Your Ref: LU/330/18/PL

RE :- Land South of Cornfield Close, Littlehampton BN17 6LD

Thank you for your correspondence of 27th November 2018, advising me of the 'Demolition of existing buildings & the erection of 77 residential homes with associated access, car parking, cycle parking, refuse/recycling storage, landscaping, earthworks & infrastructure' application for which you seek advice from a crime prevention viewpoint.

Proposed Parking Plan

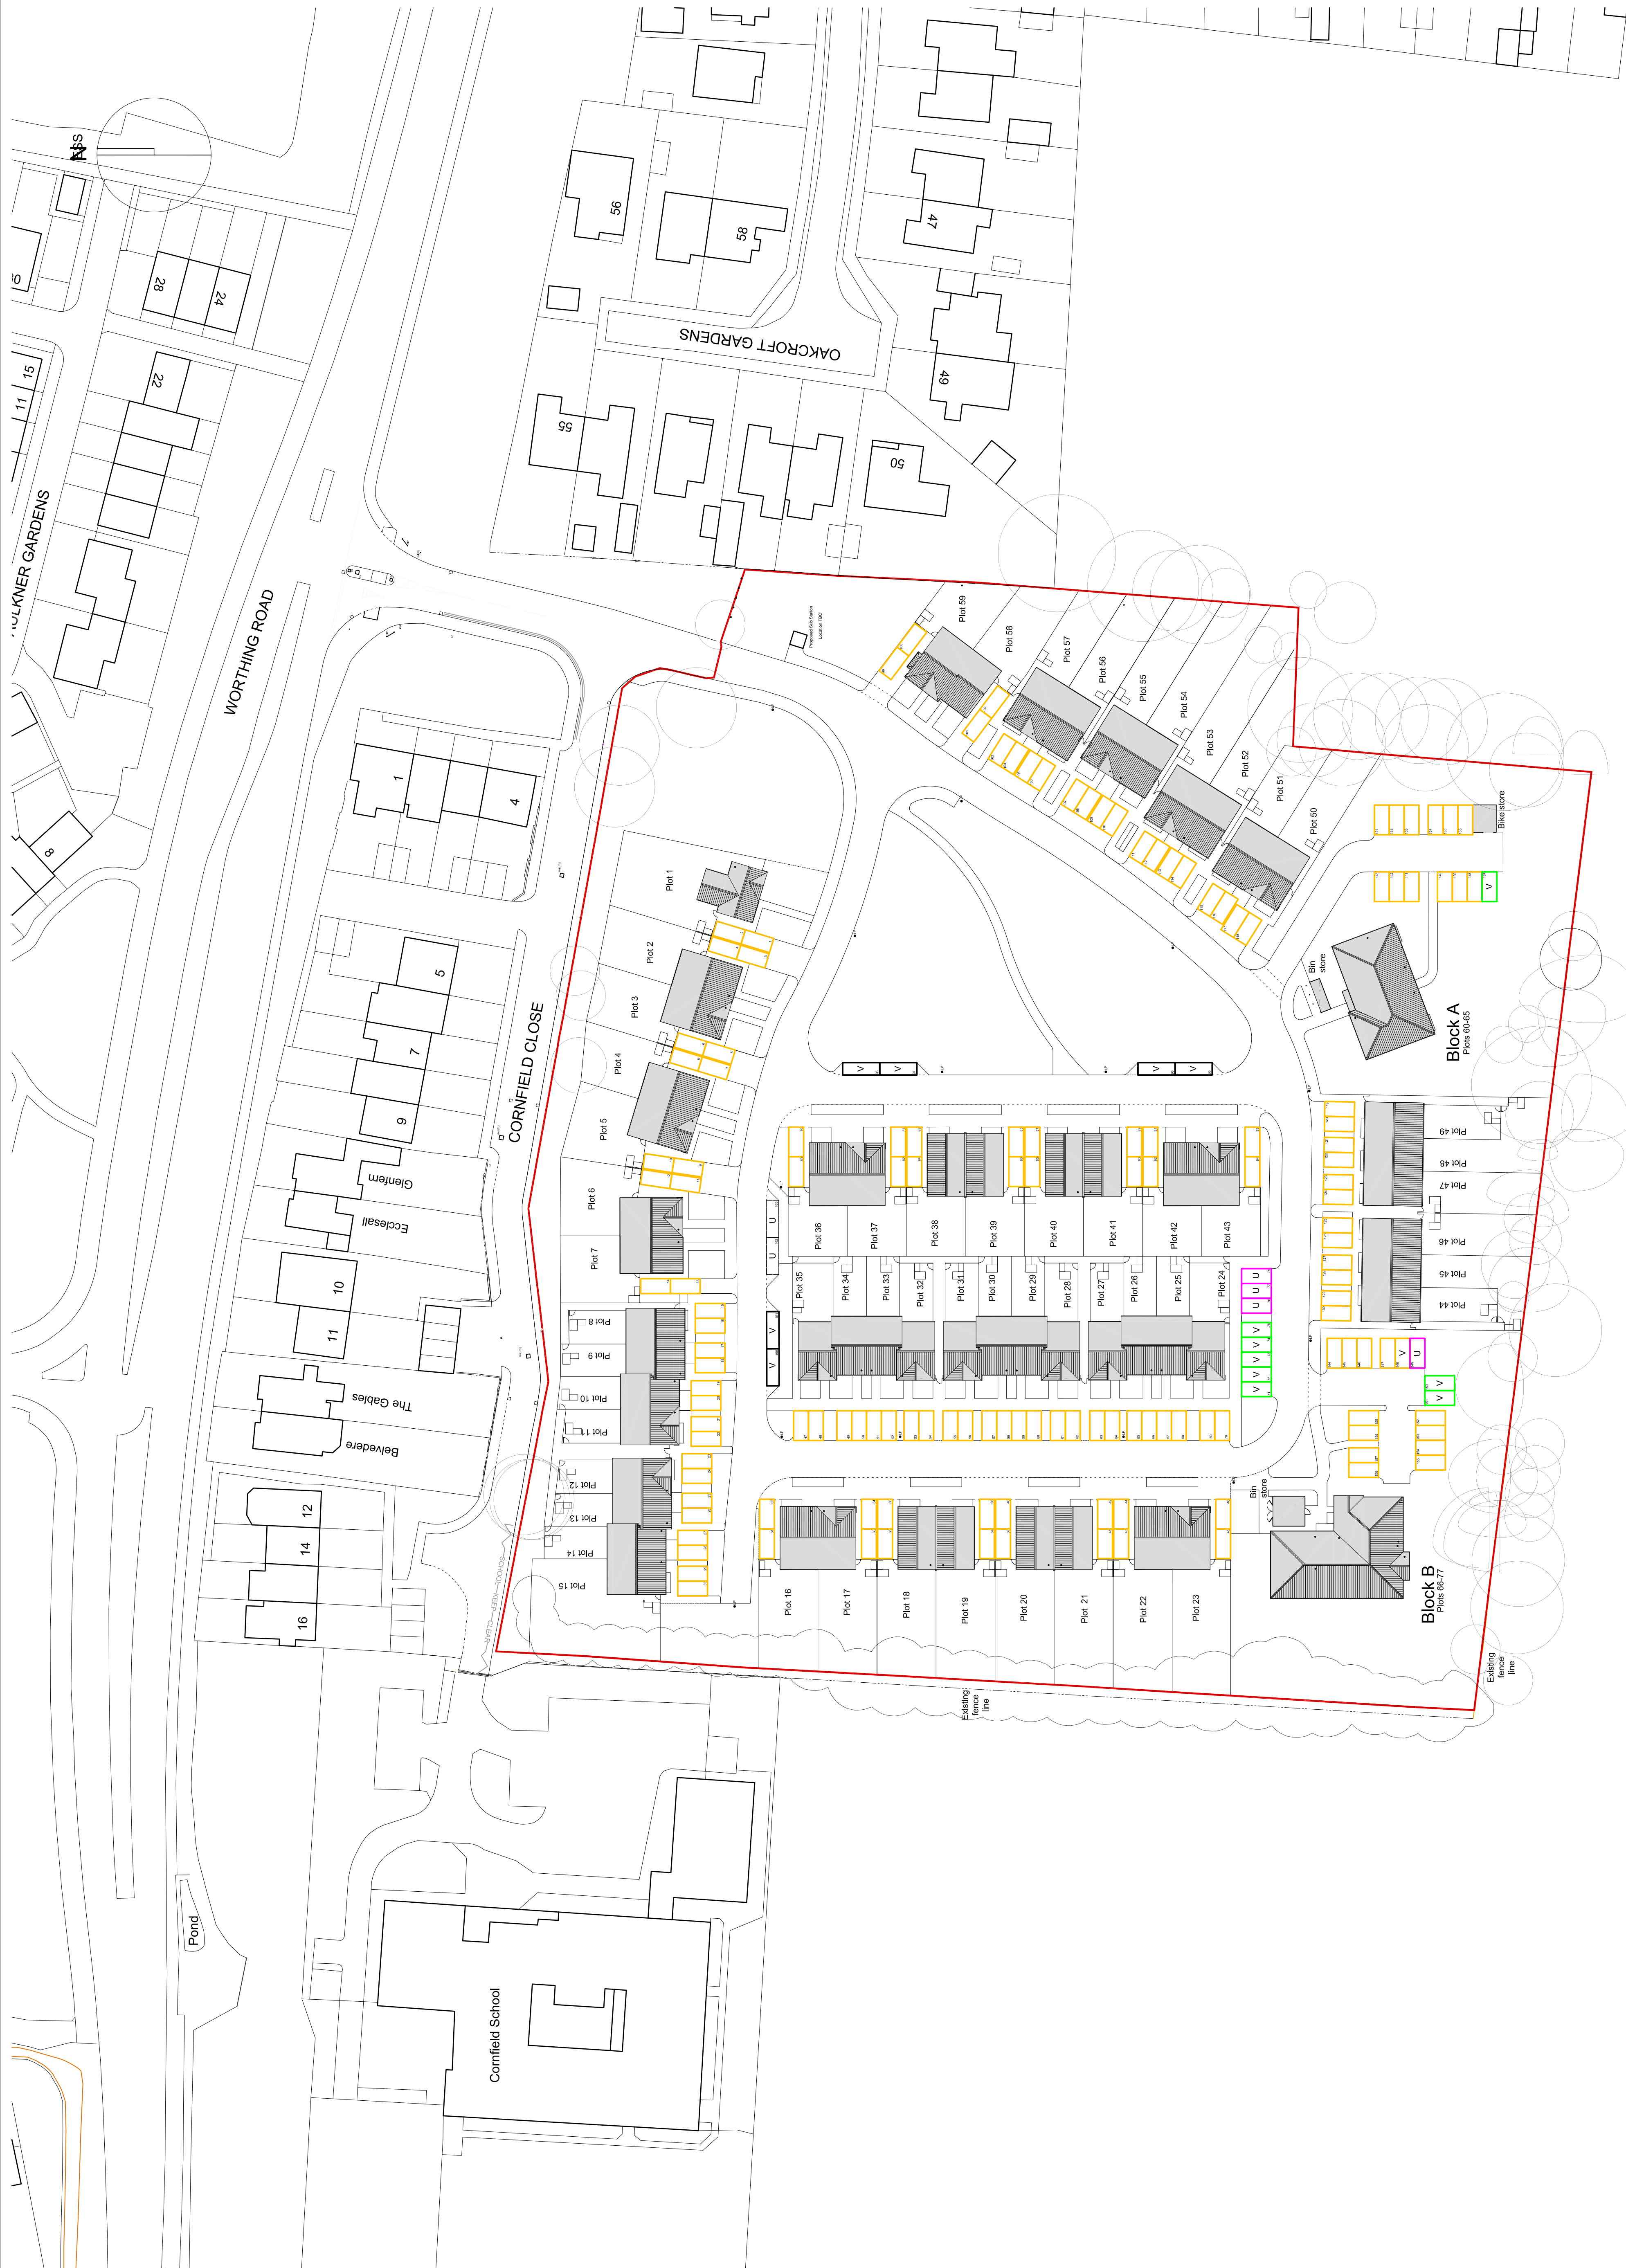
Where communal parking occurs it is important that they must be within view of an active room within the property. An active room is where there is direct and visual connection between the room and the street or the car parking area. Such visual connections can be expected from rooms such as kitchens and living rooms, but not from bedrooms and bathrooms. Gable ended windows can assist in providing observation over an otherwise unobserved area.
